# Lane Cove Bushland & Conservation Society Inc

10<sup>th</sup> May 2019

## **Submission from the Lane Cove Bushland and Conservation Society to SSD 9741, Proposed Data Centre, 1 Sirius Road, Lane Cove West**

MASTER PLAN

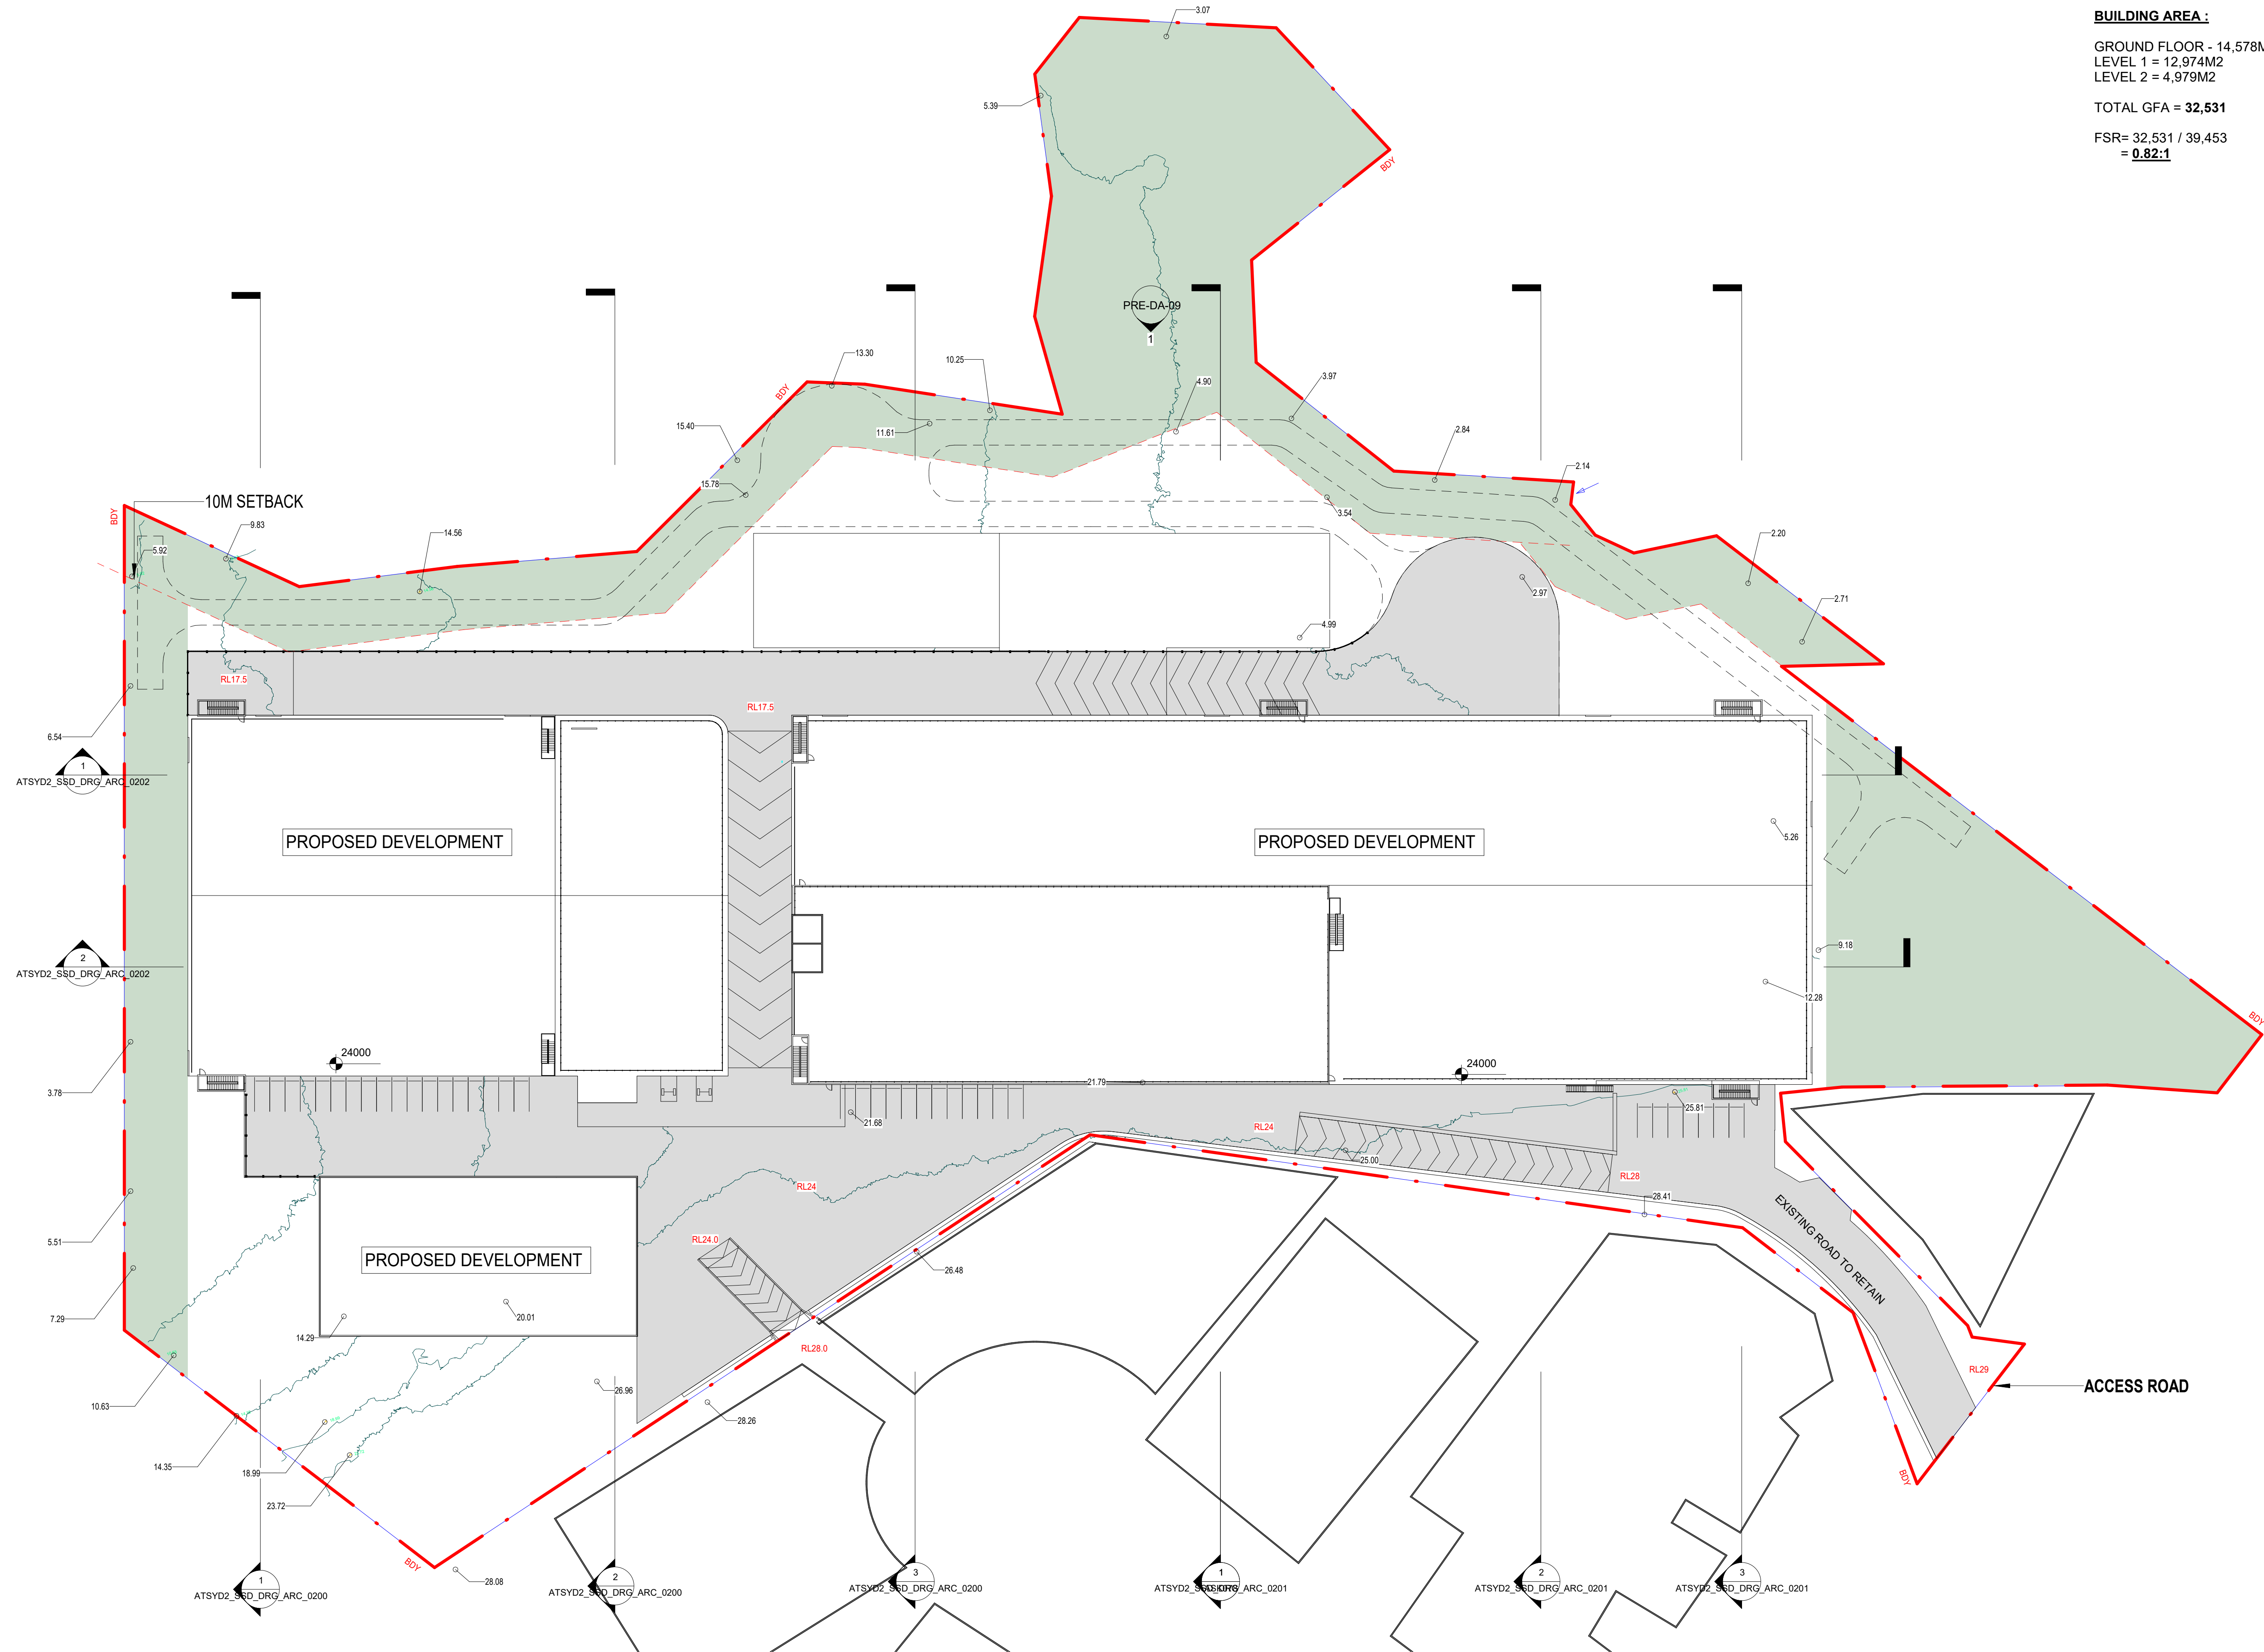
We recommend that the building be reduced in size and footprint and that the substation be repositioned which will solve some of our other objections

We recommend that the building be reduced in size and that the substation and parking area be redesigned to retain more of the natural bushland on the site.

The parking is shown as all above ground, but there is no landscaping in this to assist visually or as shade for the cars. As we have indicated we would like to see the substation repositioned and this area redesigned so that it is not built up to the level shown with massive fill falling to the south and destroying the bushland. We can see no reason to provide a complete turning circle for trucks when in most cases a three point turn is easy and acceptable to most drivers. This would reduce this area and help the bushland.

We suggest that multilevel carparking be investigated to reduce the footprint of this unsightly hard paved area.

1 ROOF PLANT LAYOUT
SCALE: 1 : 500

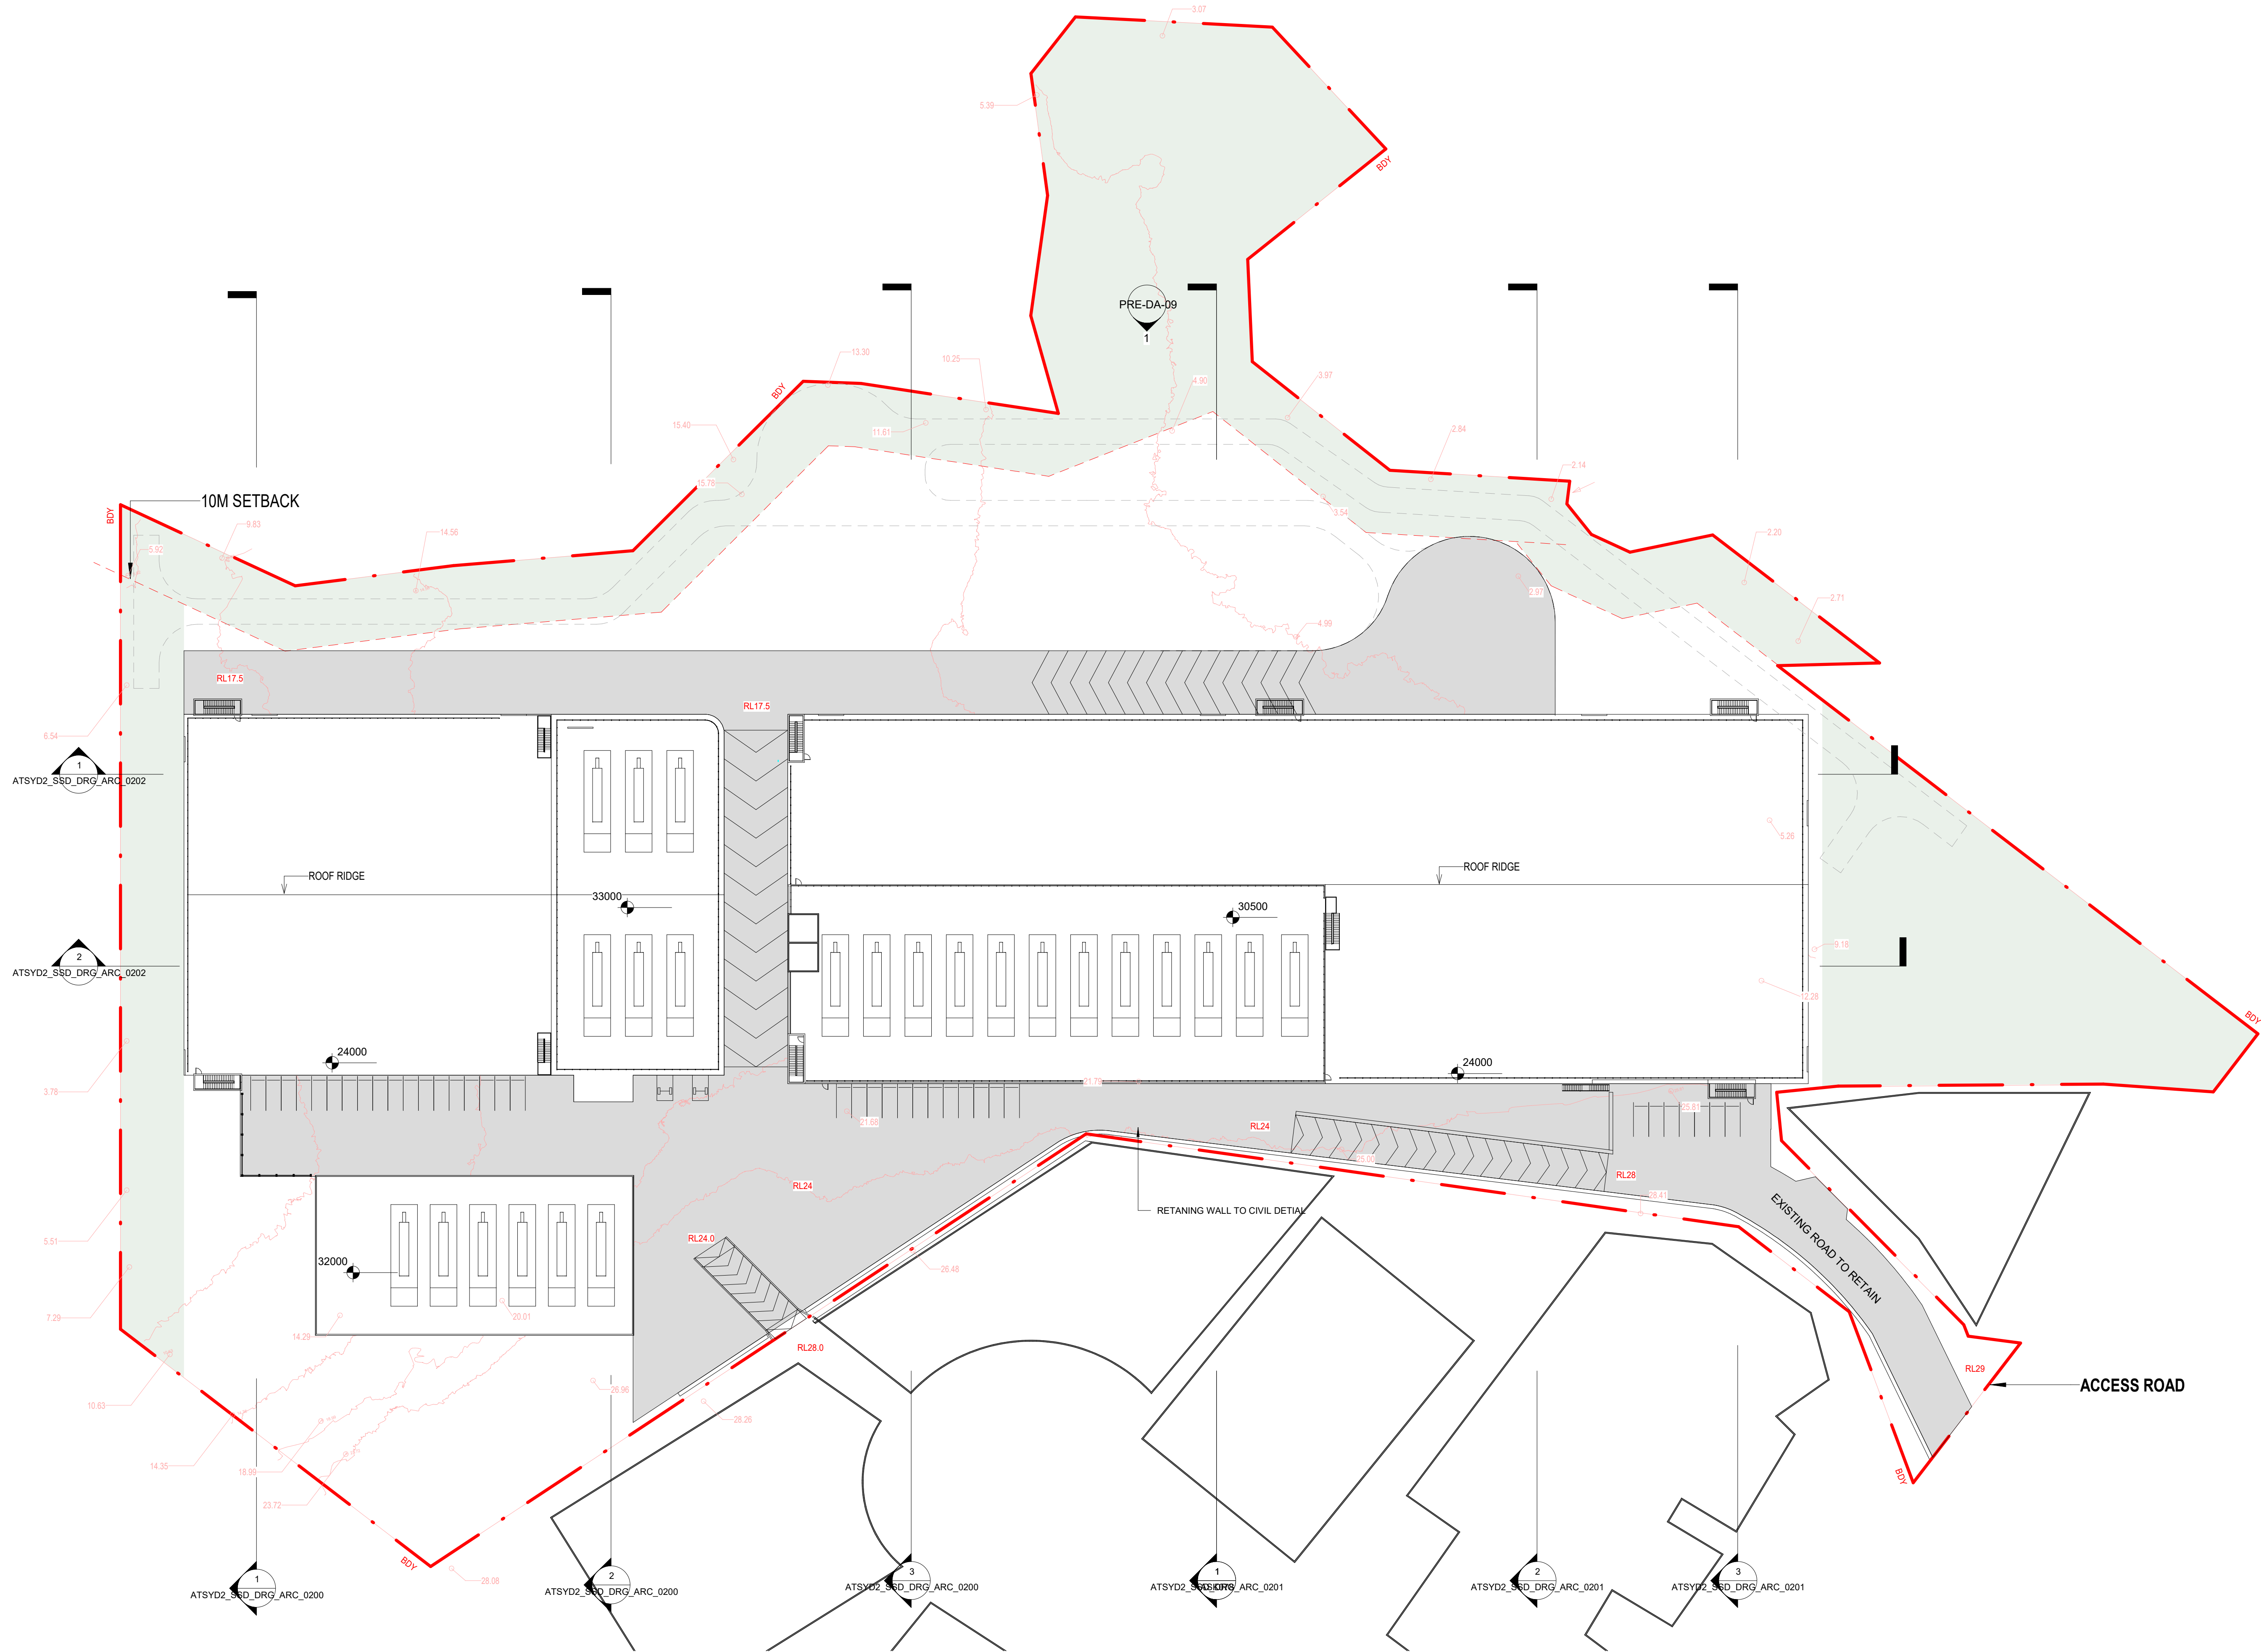
The mechanical plant on the roof with their acoustic enclosures must be considered as plant space and not roof space. This makes the extent of plant spaces, one complete floor, roof area, three level plant platform and substation, greater than the calculable area. This amount of plant may be necessary for the use but it should in part be calculated more in the line with normal light industrial use and included in the GFA.
